Date: 11-15-2023

Job number: 2023-8-1-Varko

Traffic Memo for 1185 N Curtis Rd

TITLE:
SITE PLAN PROPOSED CONDITION

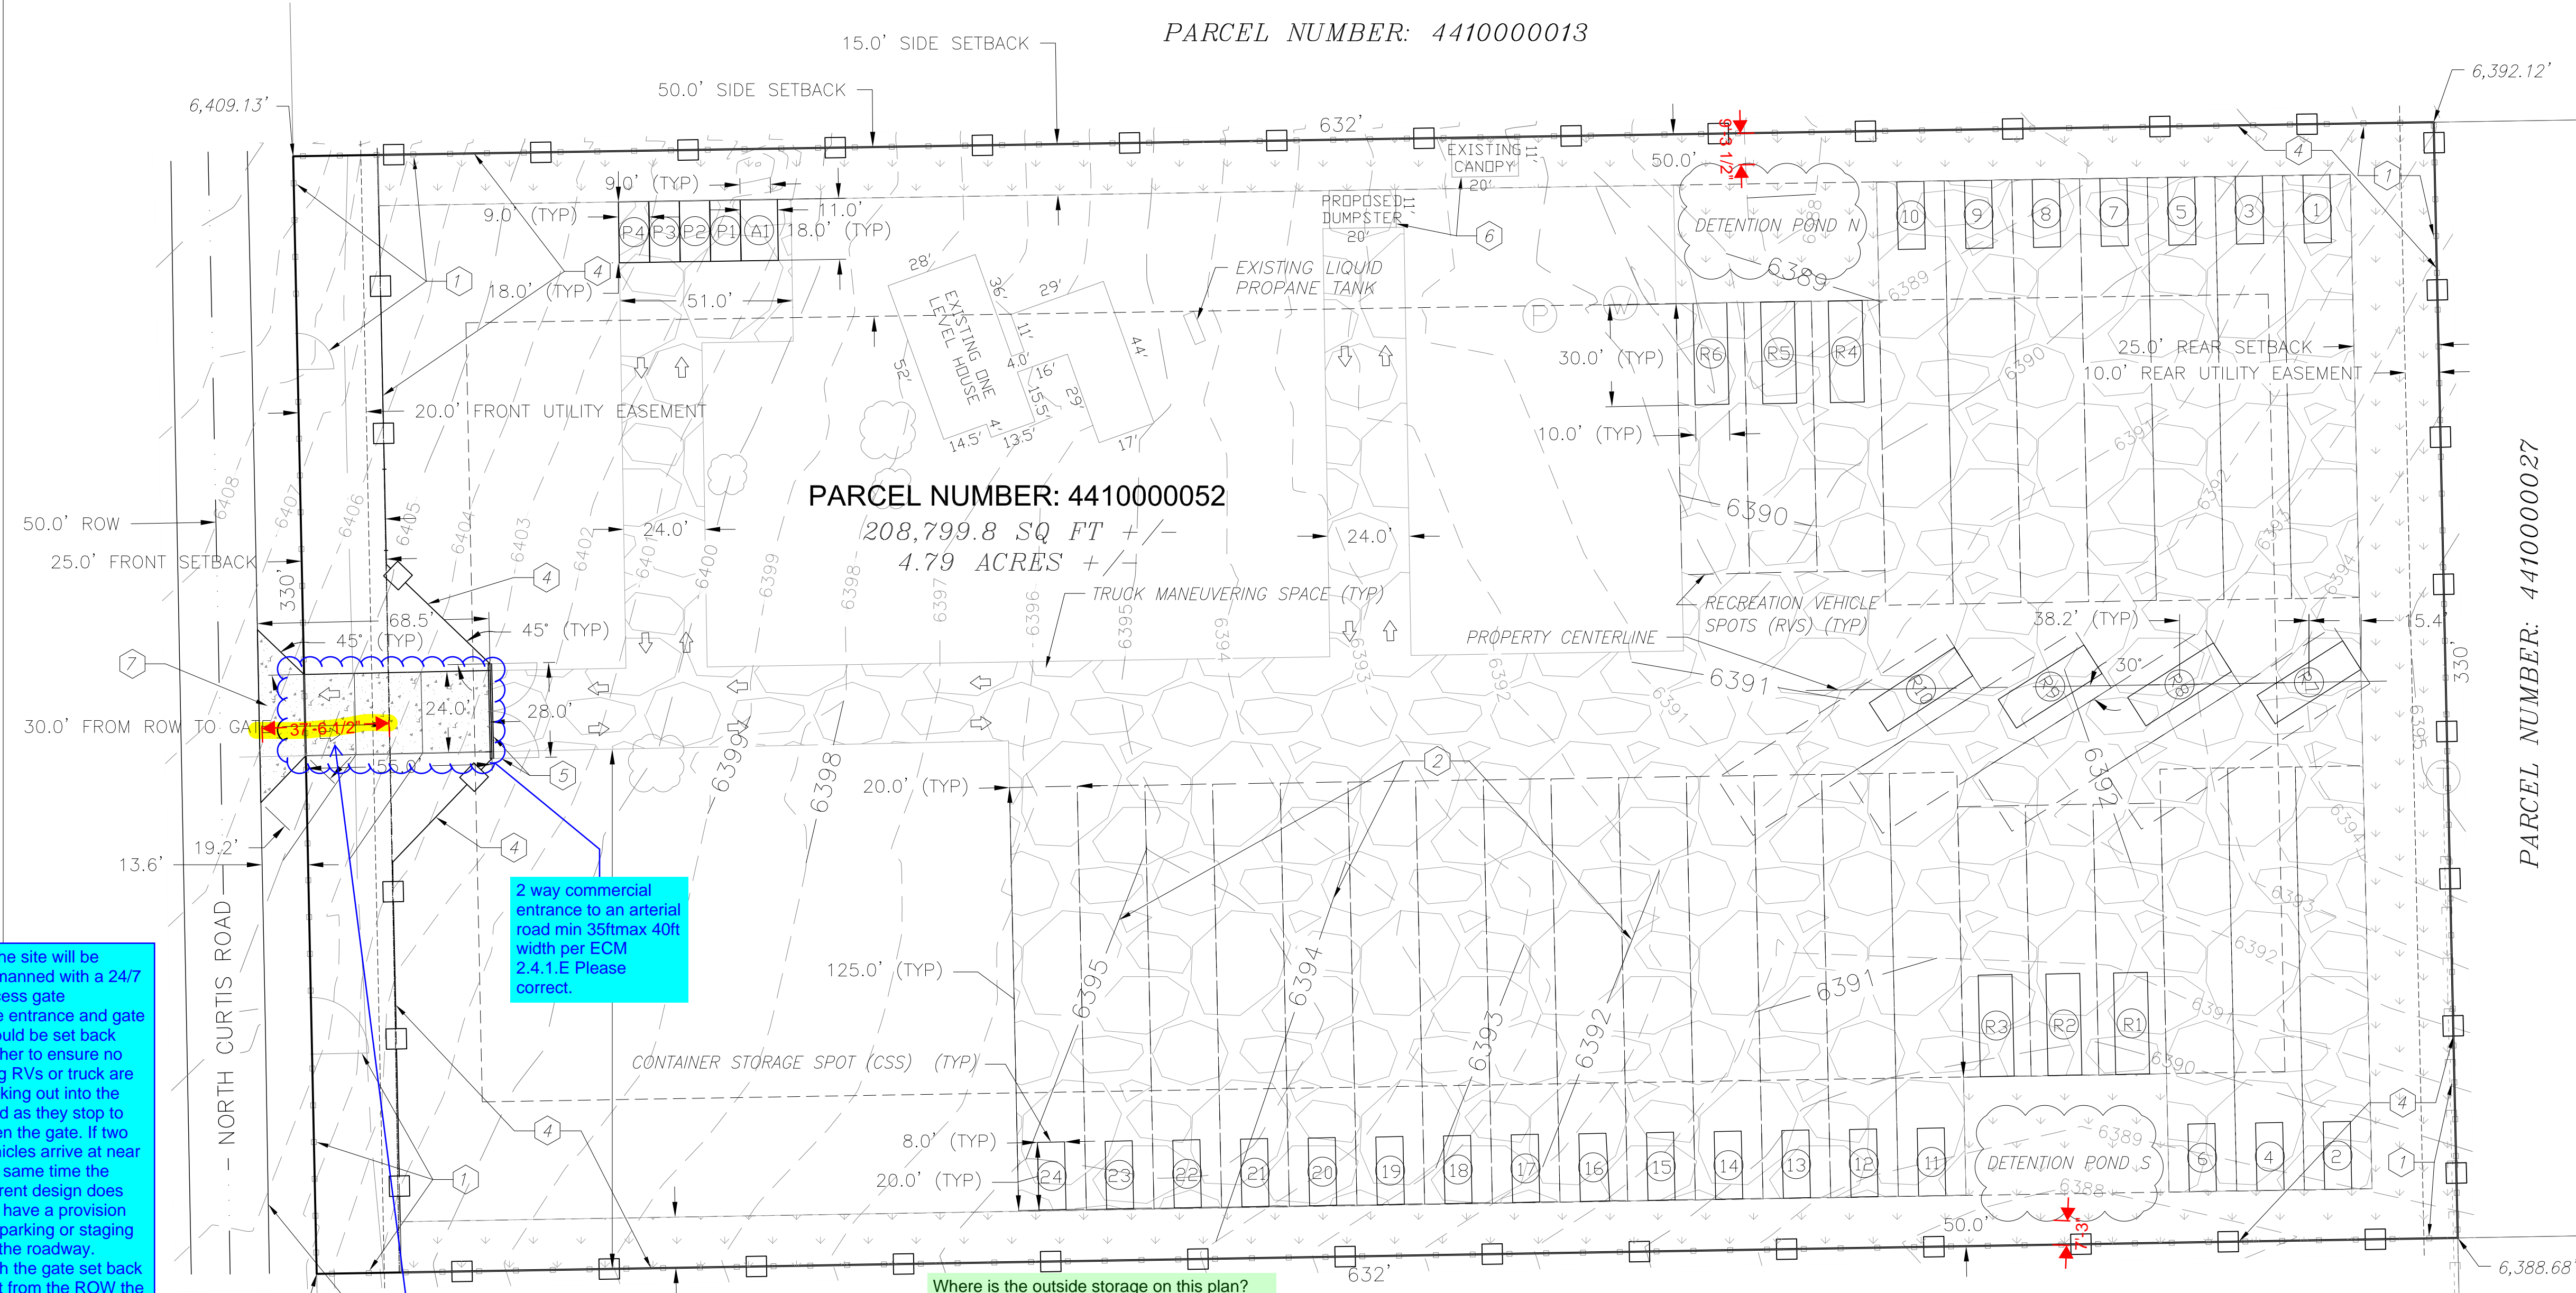
Please state what the sight distance is for every affected access and whether it can be met. If it cannot be met, state the required modifications so that it can be met. Refer to Table 2.35 of the ECM Single Unit truck design vehicle

Any gates must be set back from ROW as detailed in the LDC for proper setback to not block the ROW. Gate shall be centered on the west lot line. The gate shall be 28 feet wide. Gates shall be located a minimum of 30 feet from the public right-of-way and shall not open outward. The opening provided through a gate shall be 2 feet wider than the traveled way.
